Application No: BN/2/21/DOC
Registered: 13th January 2021
Site Address: Flamsteed Lake Lane Barnham PO22 0AD
Description of Works: Approval of details reserved by condition imposed under BN/130/19/HH relating to condition 3-surface water drainage.

From: Paul Cann
Sent: 22 December 2020 13:34
To: June Grinstead
Subject: RE: Flamsteed, Lake Lane, Bognor Regis

| Project number | FLA-19            | D102          |

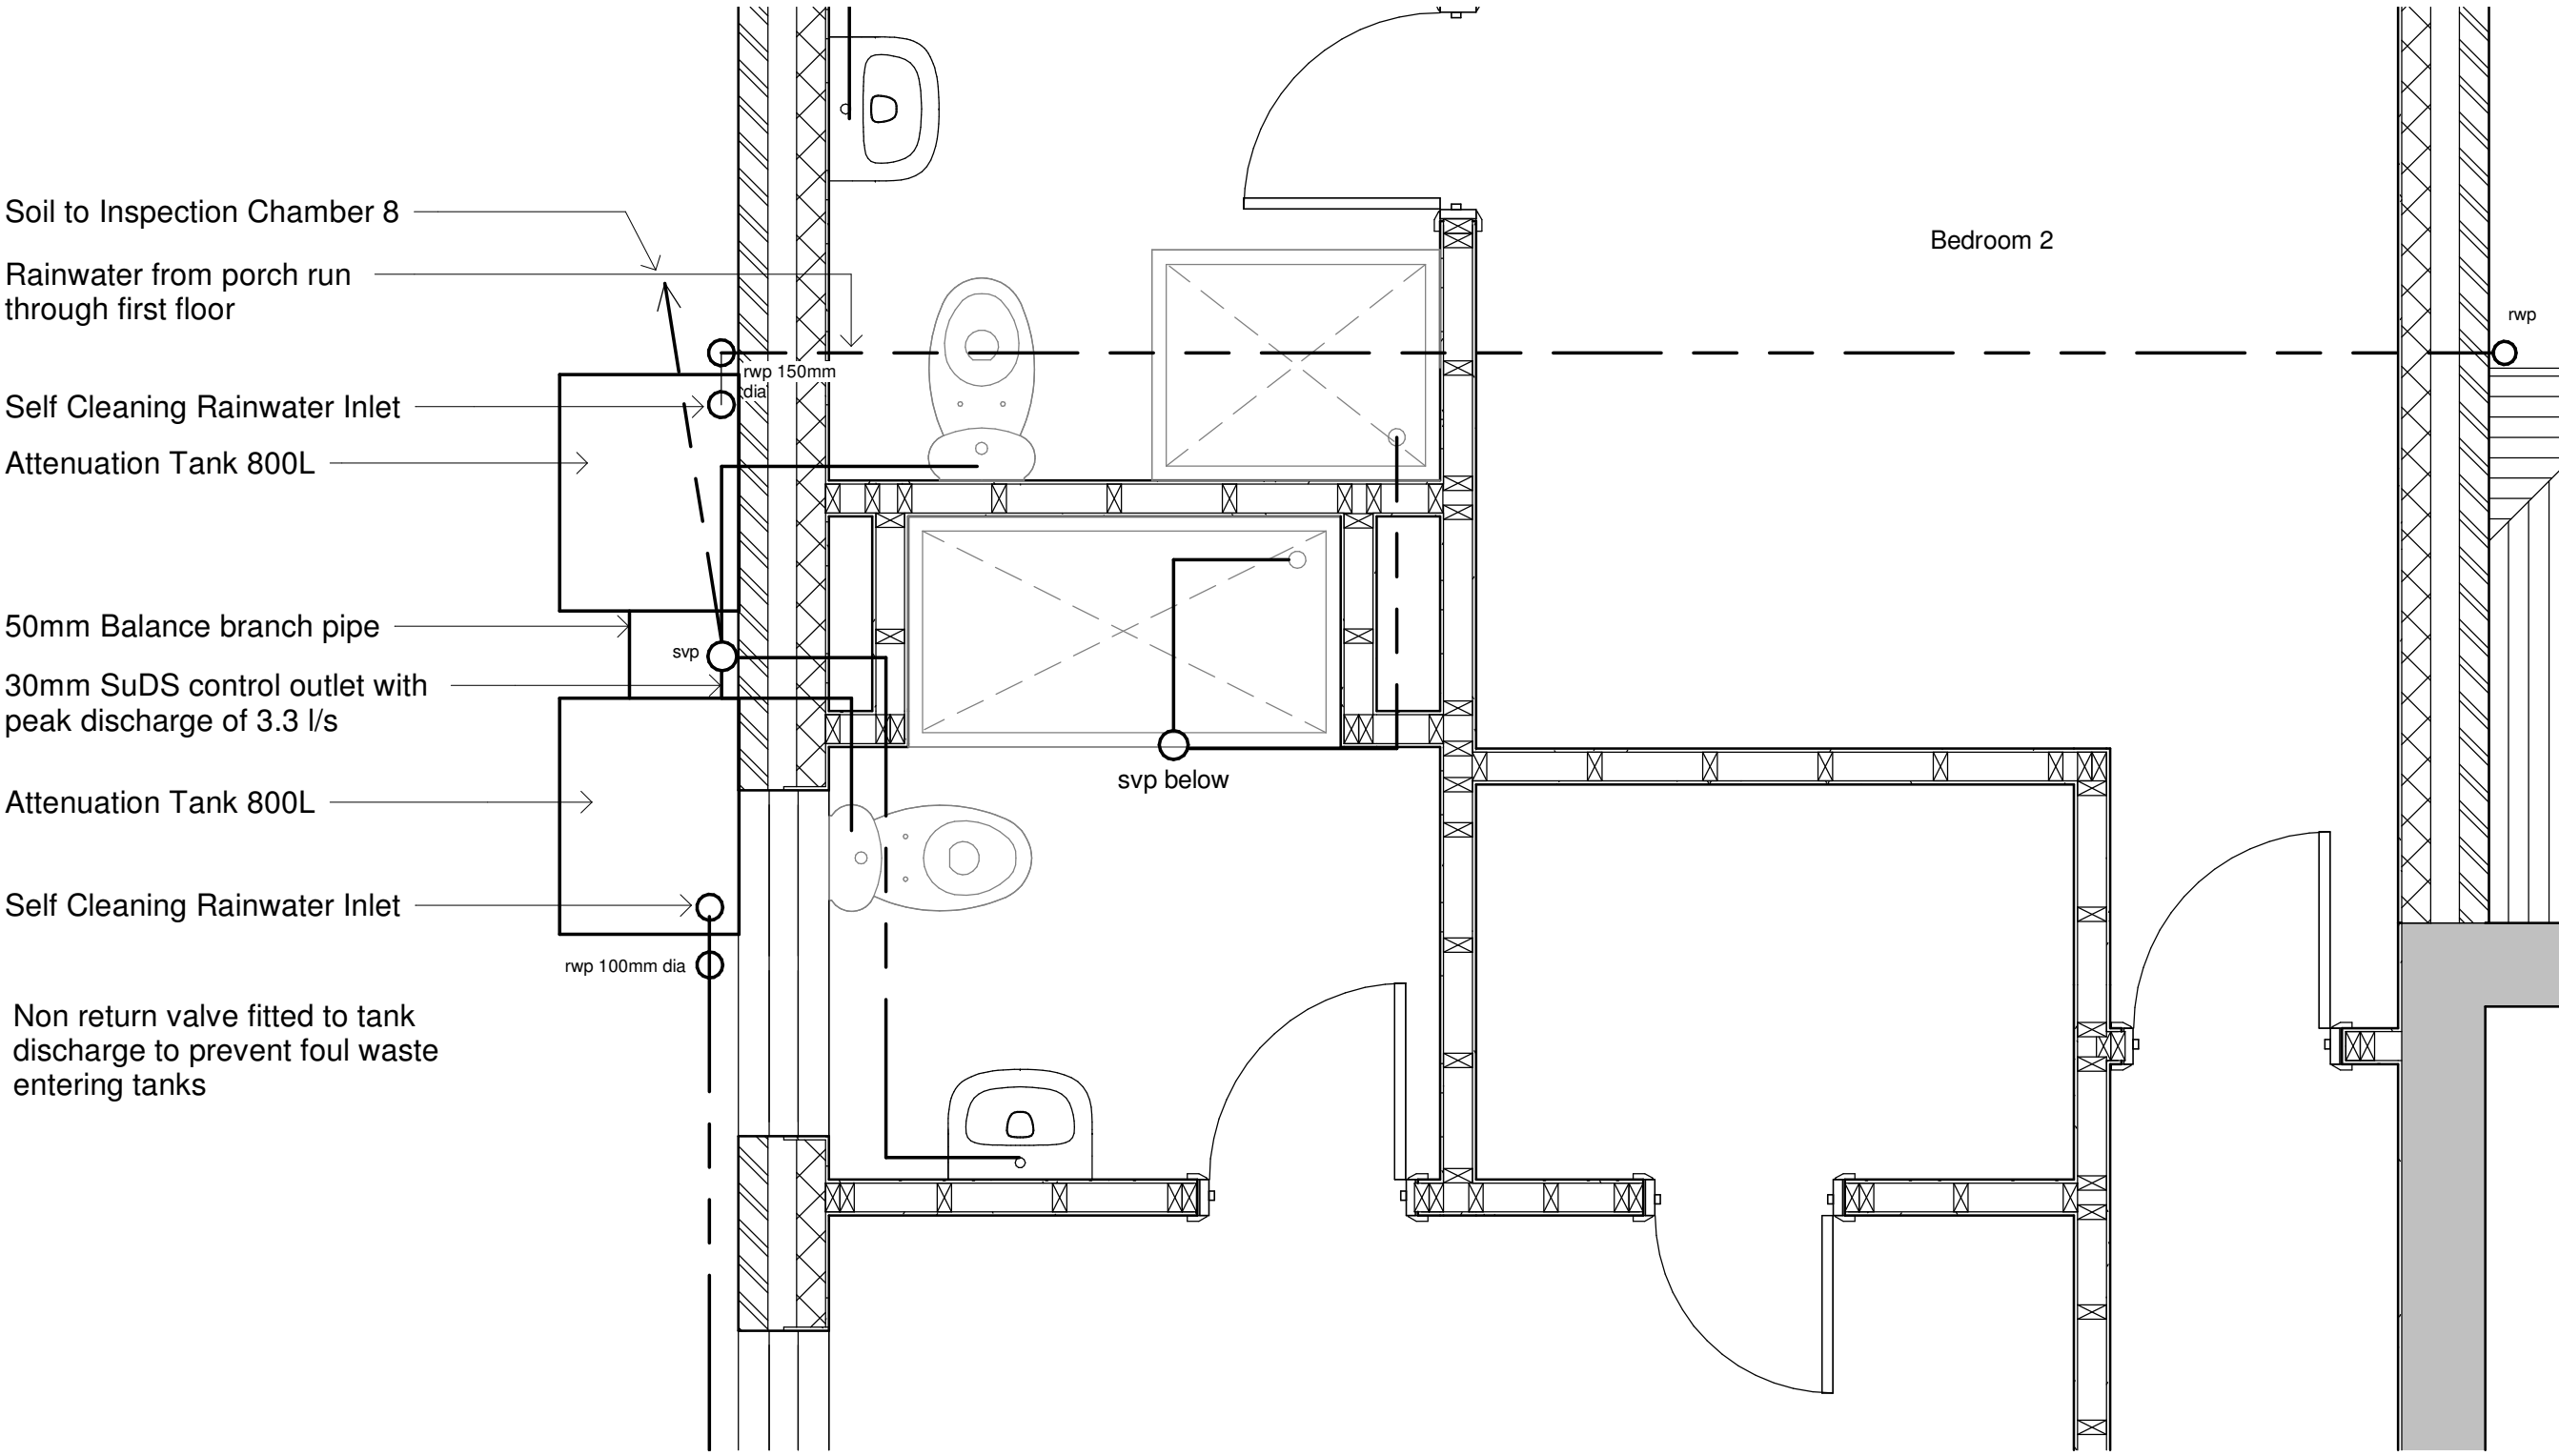
2. Please confirm that there are only two rainwater pipes on the property post development. I know they are shown on the elevations but also need to be included on drg. D102.

4. The notes on drg. D102 reference the use of soakaways – note needs to be removed.
5. Add pipe gradients to drg. D102 for the combined pipework ie. for each length. Manhole cover levels for the combined system should also be provided (with the invert levels relative to these).
